6 June 2022

RE: Main Response Report - Kings Park Metal Recovery and Recycling Facility Expansion (SSD-10396)

1.0 Department of Planning and Environment

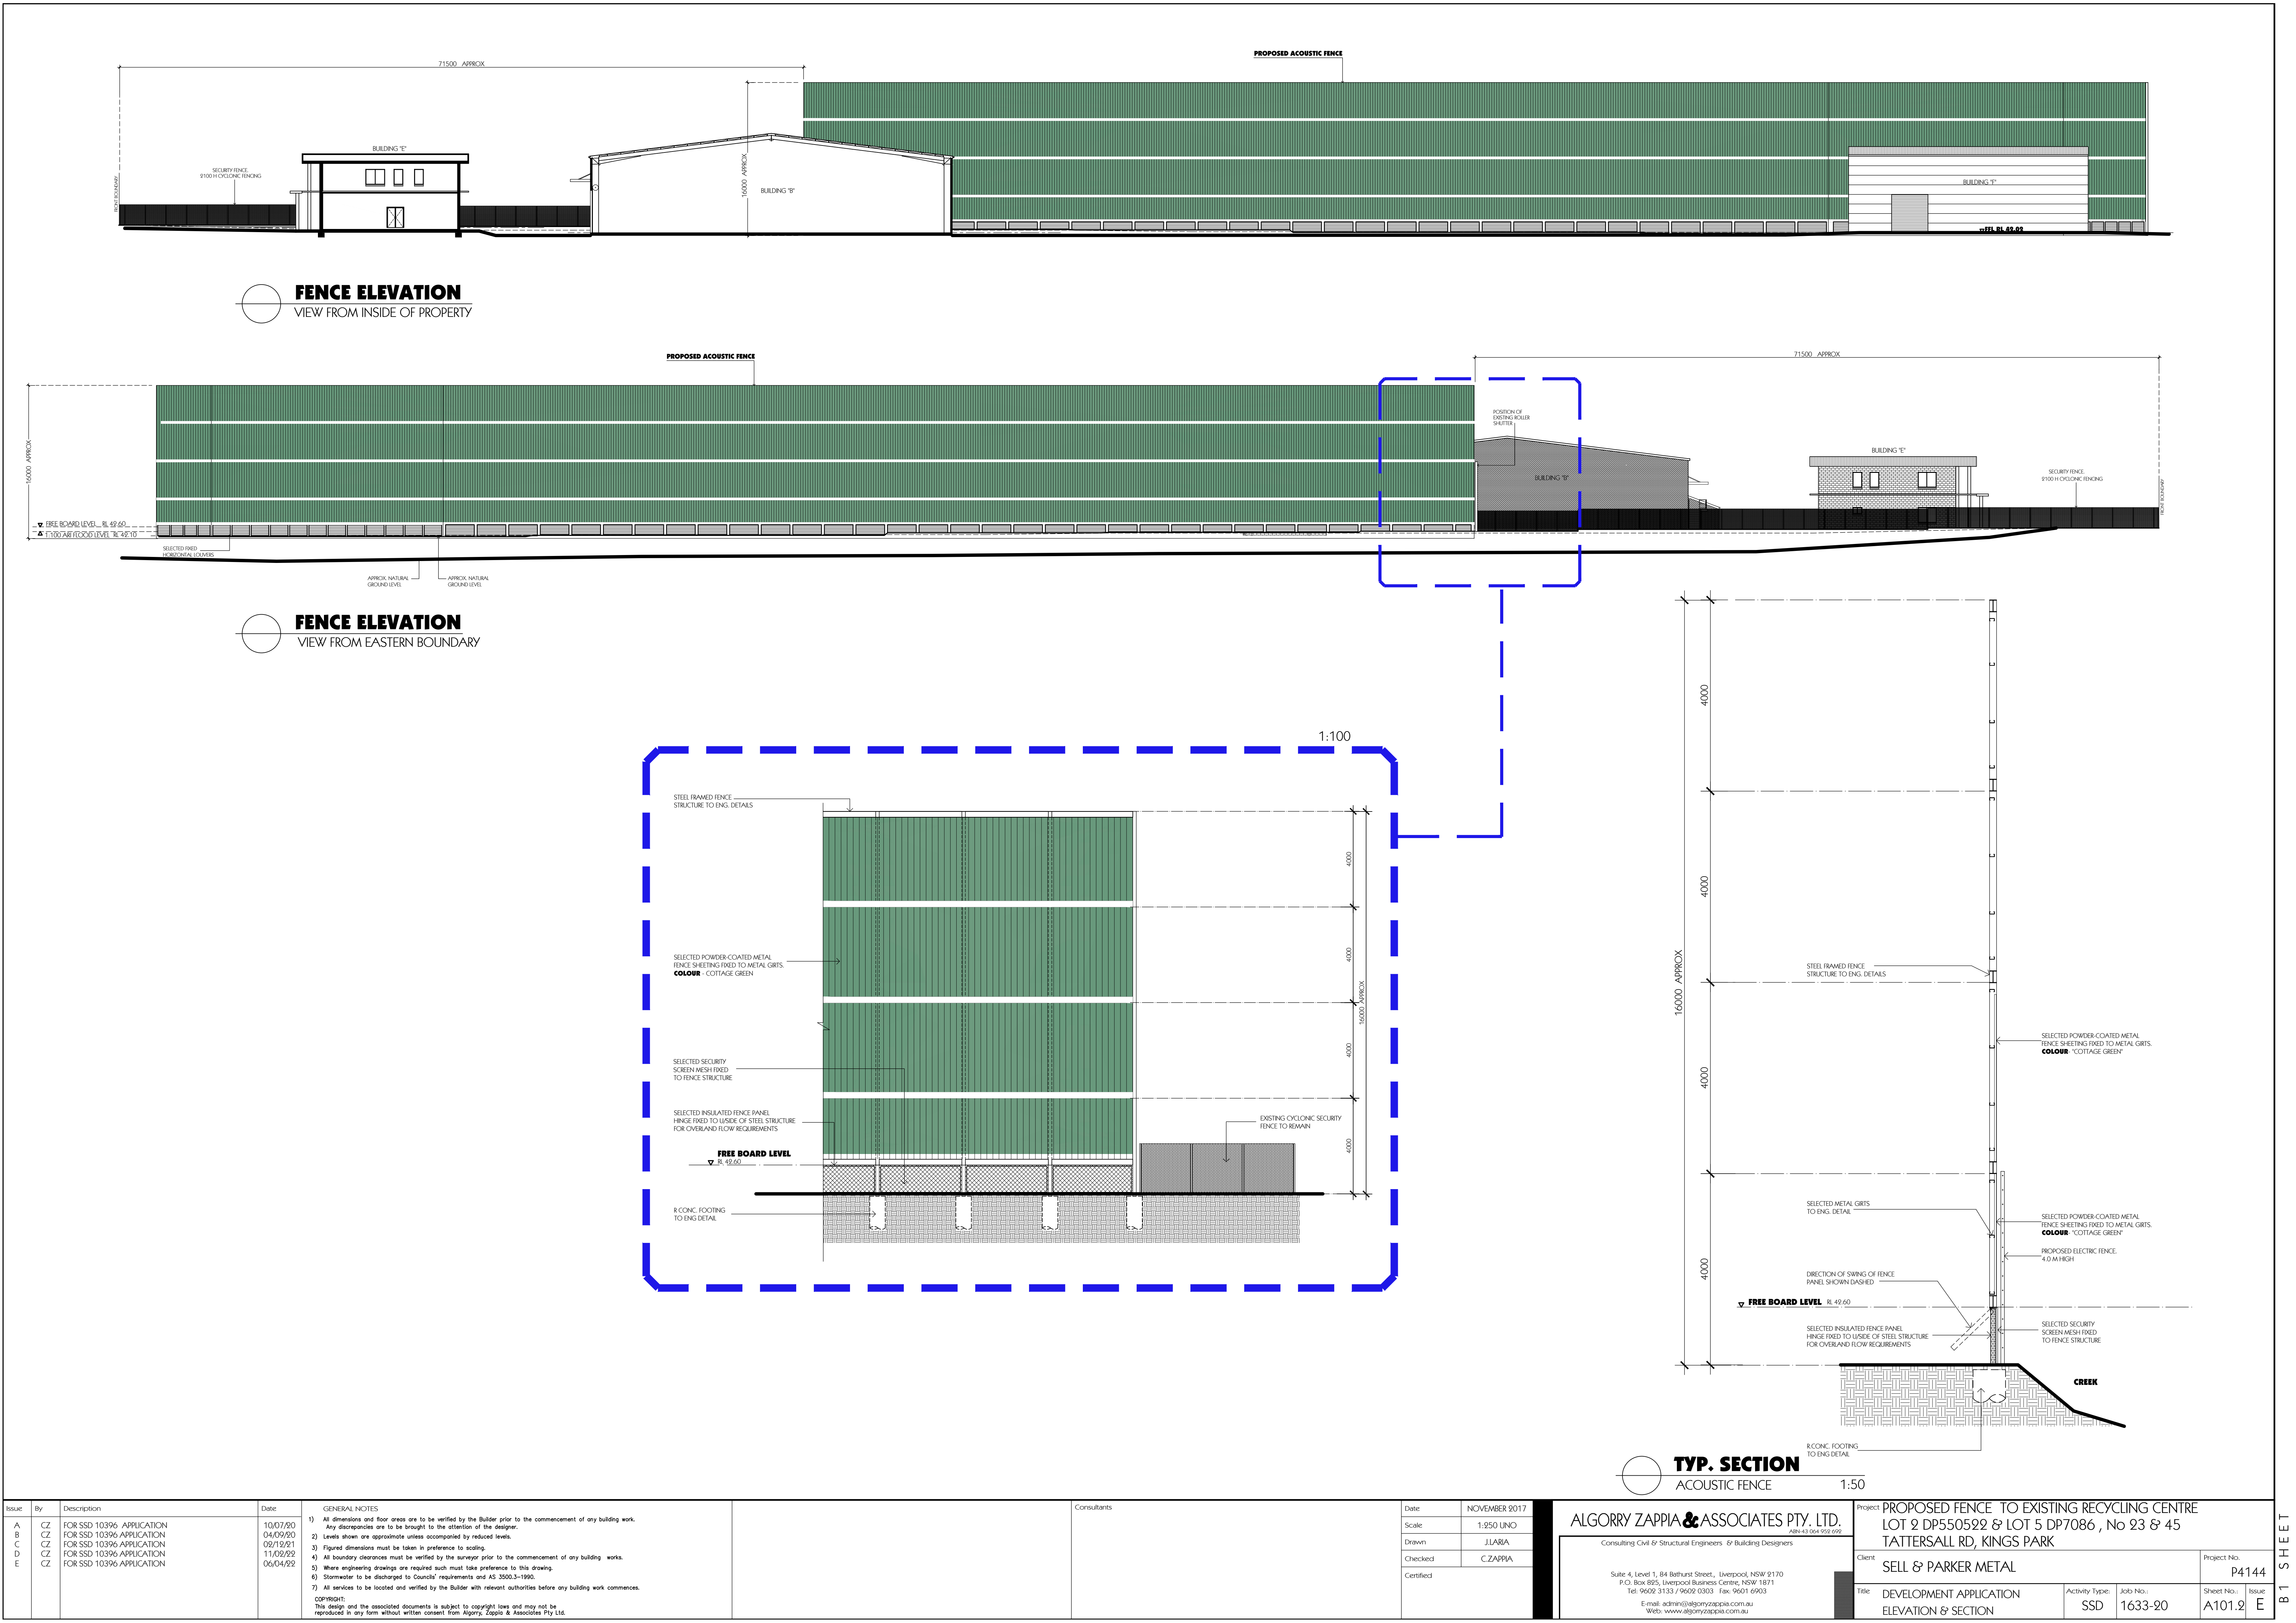
Aspect	Issue	Response	Reference
Plans	The Department notes the Stockpile Plan (Final Stockpile Plan Approved by LEC Proceeding 2020/00365487) has been described as an 'end of day' plan. Please provide a worst-case working stockpile plan (rather than an end of day plan) which shows drop off and loading points and demonstrates that heavy vehicles can access the active site, stockpiles and relevant buildings.	The Stockpile Plan (Final Stockpile Plan Approved by LEC Proceeding 2020/00365487 – submitted as Appendix E of the RtS – Additional RFI) is considered an 'end of day plan'. As discussed within the previous submission, the Stockpile Plan includes areas for combustible and non-combustible material. The movement of material is dynamic throughout the day based upon the operational requirements (types of materials received, processed and departing the site). The Proposal site does not generally maintain 'stockpiles' during the day. Instead, working piles are created in the available space between vehicle routes. Working piles would not intrude upon the identified access routes (denoted in green on the Swept Plan - Supplementary Traffic Information (Appendix F of the RtS – Additional RFI)) at any time throughout the daily operations. It is understood that a key concerns from DPE is that suitable vehicle access (for both operational and emergency vehicles) is available throughout the day. Rather than provide several stockpile or access plans, Sell & Parker proposes to implement a mitigation measure which would ensure access routes are maintained throughout the day and that material is not stored within these areas. This would ensure that internal site vehicle routes are maintained at all times. The proposed mitigation measure is as follows: Access and egress routes/swept paths and truck stacking areas identified on the Swept Path Plans (dated 17 November 2021 prepared by TTPP) would be maintained clear of any materials, plant or equipment at all times during operations and at the end of daily operations.	Stockpile Plan (Appendix E of the RtS – Additional RFI) Mitigation Measures (Attachment I of this response)

It is unclear from the swept paths shown on the Stockpile Plan if the access routes to the west of the combustible stockpiles, to the north of building B and between Building C and the existing shear are intended for use by the largest vehicle accessing the site. Please update the plan to demonstrate which vehicles can access the shown paths. His understood that DPE are referring to the swept paths, shown on the Stockpiles, to the north of use by the largest vehicle accessing the site. Please update the plan to demonstrate which vehicles can access the shown paths. His understood that DPE are referring to the swept paths, shown on the Stockpiles, to the north of the shown below. Supplementary Traffic Information (Appendix F of the RtS – Additional RFI). Swept Path Plans (Attachment C of the response)
As identified within the Supplementary Traffic Information, the largest vehicle (19m semi-trailers) would only travel along routes identified by the swept paths with the red wheel path outline. The locations identified by DPE are additional vacant access routes which could be used by emergency vehicle routes if required (in addition to the circulating routes throughout the Proposal Site (i.e. along the 19m semi-trailer path)). Further, along the north of Building B (non-ferrous building), vehicles delivering non-ferrous material would use this route only. This includes 8.8m Medium rigid vehicles or smaller vehicles. No semi-trailers will use such route (and therefore this route is not denoted with a red wheel path outline (refer to Sections 3.2.1 and 5.1.1 Supplementary Traffic Information).

Aspect	Issue	Response	Reference
	Show, on the site plan, where the bins, large spare parts and cranes would be stored if the 'storage area' to the south of Building C is used for queueing trucks.	It is noted that the Swept Path Plans identifies an access and stacking areas of heavy vehicles to the south of Building C (refer to <i>Attachment C</i> of this response).	Swept Path Plans (Attachment C of this response)
		This area is currently utilised for the storage of disused plant and equipment. The plant and equipment are currently stored at this location for convenience only and not utilised in Sell & Parker's day to day operations on the Proposal site. All vehicles, equipment and containers currently stored within the area identified for access and stacking would be stored off-site at another Sell & Parker facility or another location.	Mitigation Measures (Attachment I of this response)
		As discussed above, a mitigation measure (provided within <i>Attachment I</i> of this response) is to be implemented to ensure that these vehicle access routes and stacking areas remain clear and available for operations. This plant and equipment would be relocated off-site prior to operations to comply with this mitigation measure.
